Application for Planning Permission for Works or Extension to a Dwelling

Development: Proposed side dormer.
Location: 22 Sefton Avenue Aldwick PO21 3BN

Proposed Ground Floor Plan

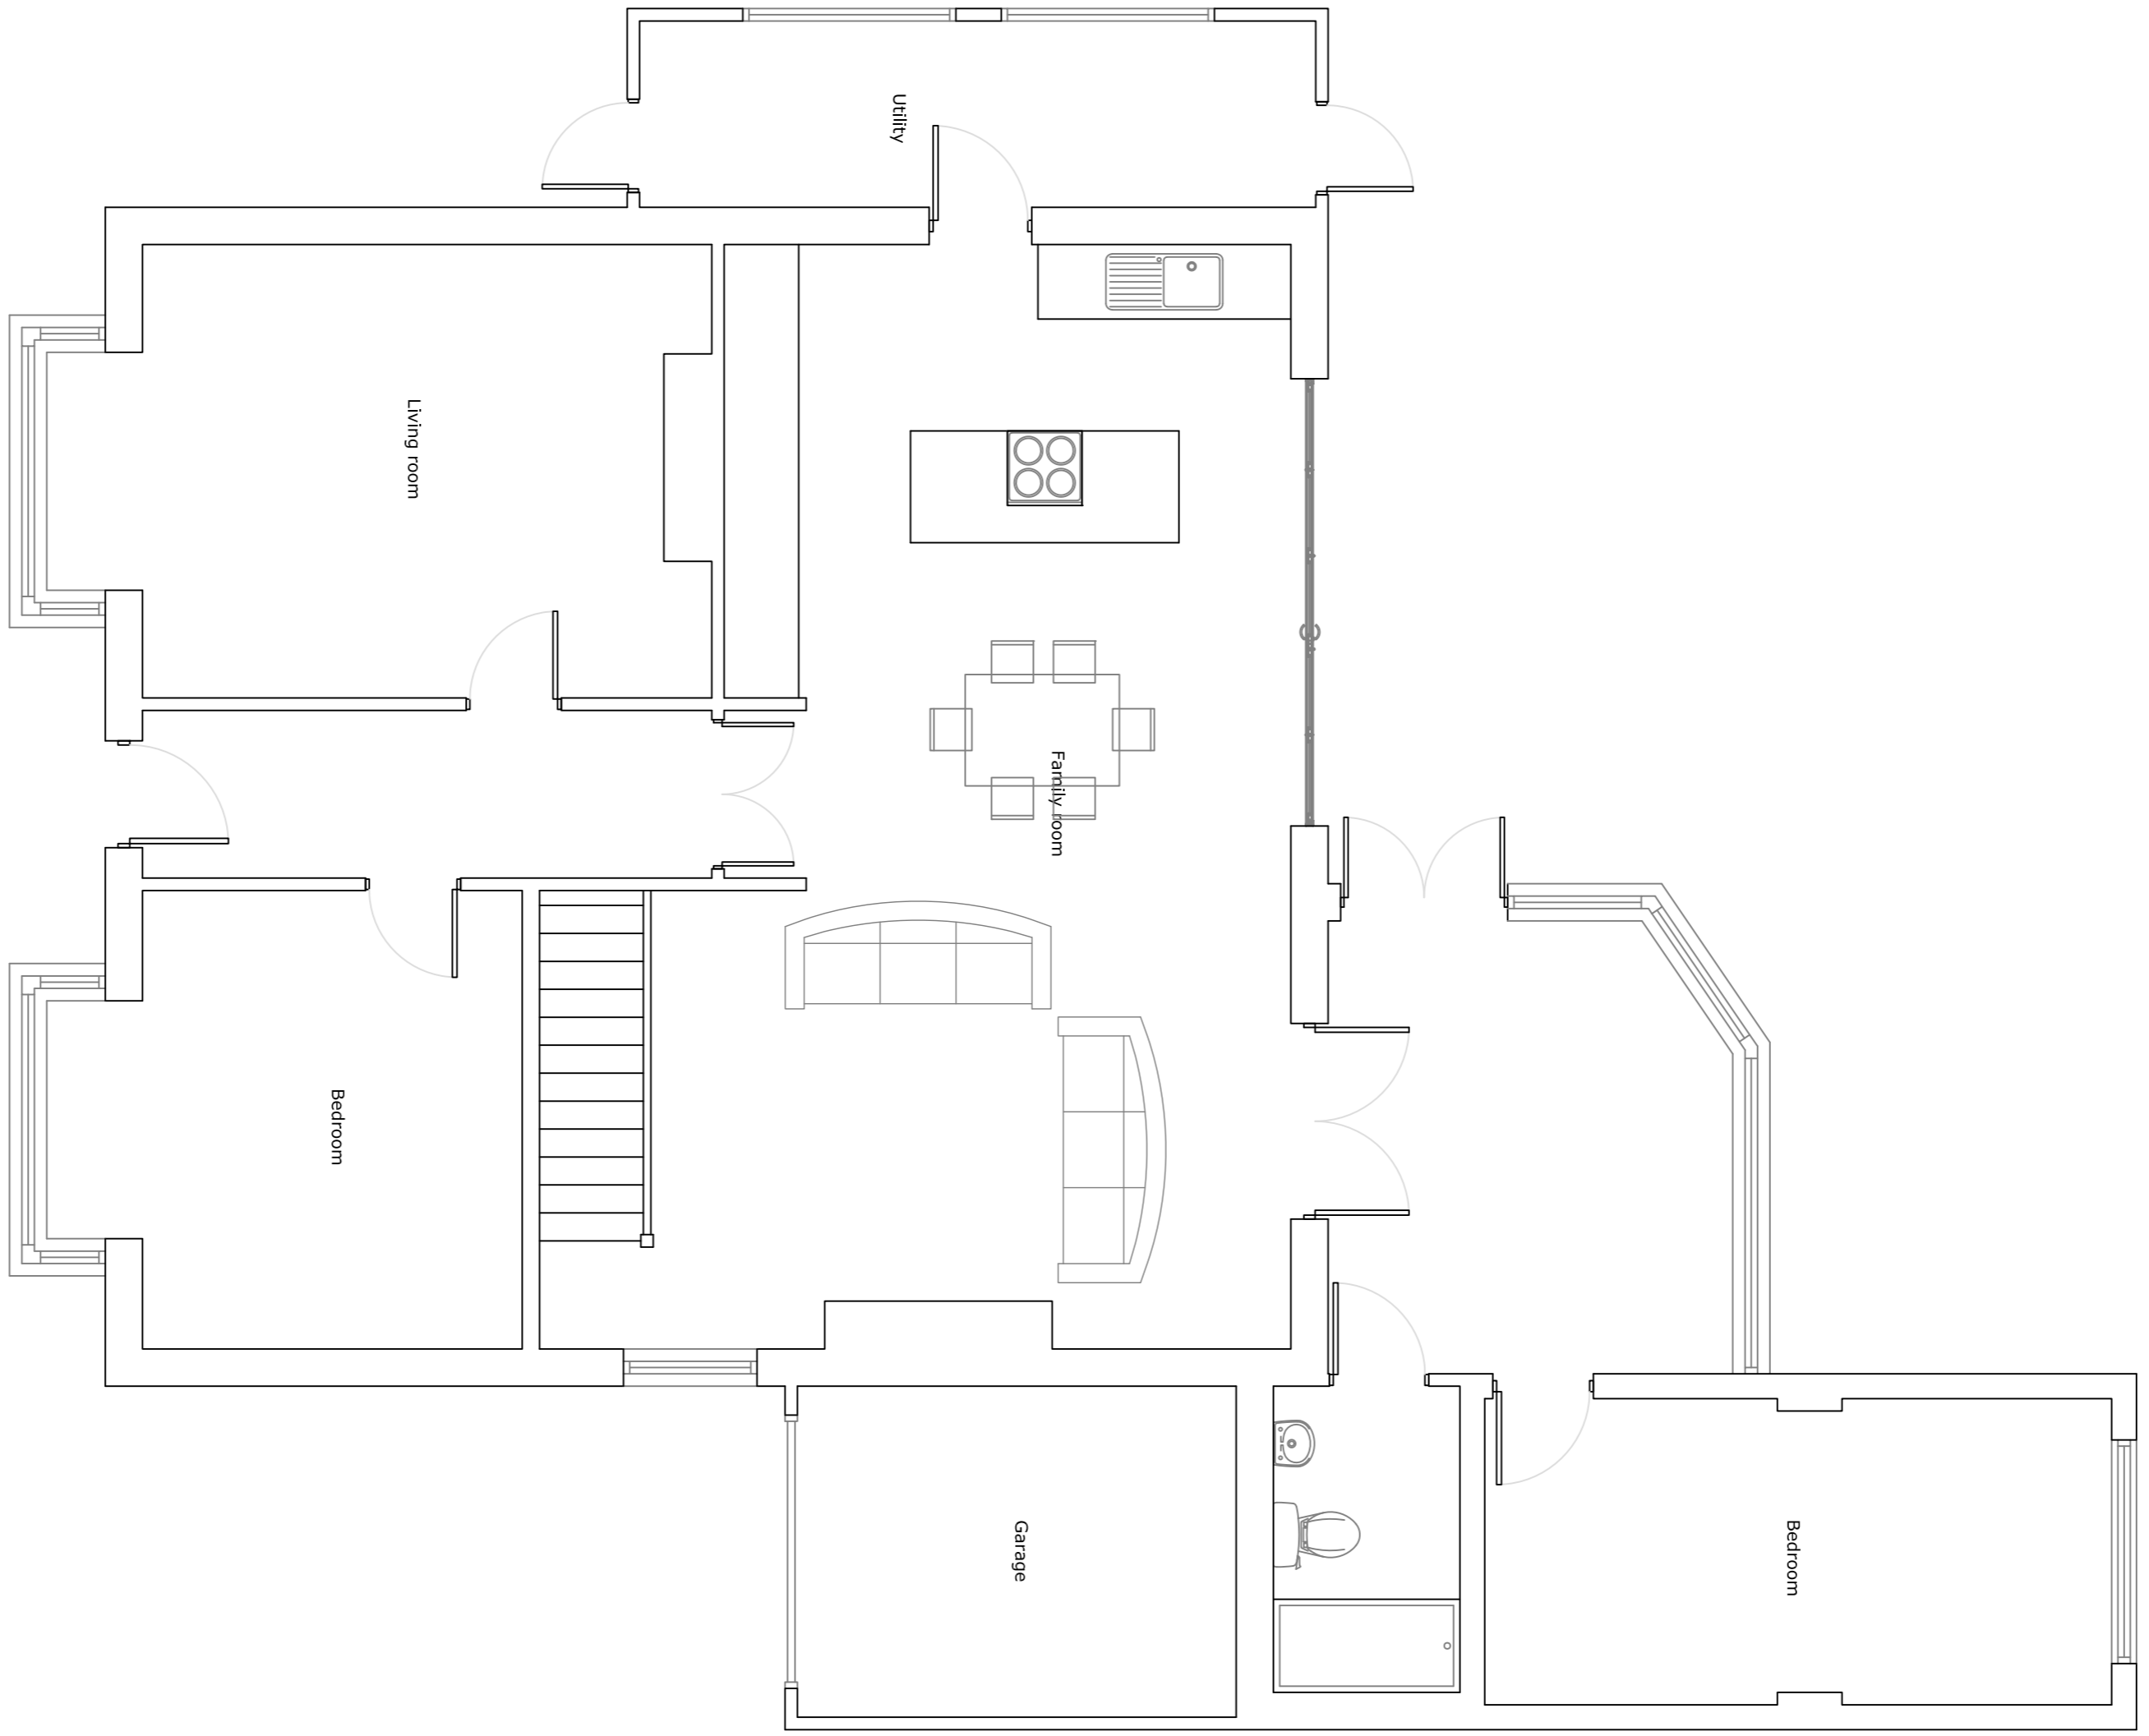
The proposed plans show a partial garage conversion, please either add this to the proposed description of works, or remove it from the plans. Please note, with your permission we can add this for you.
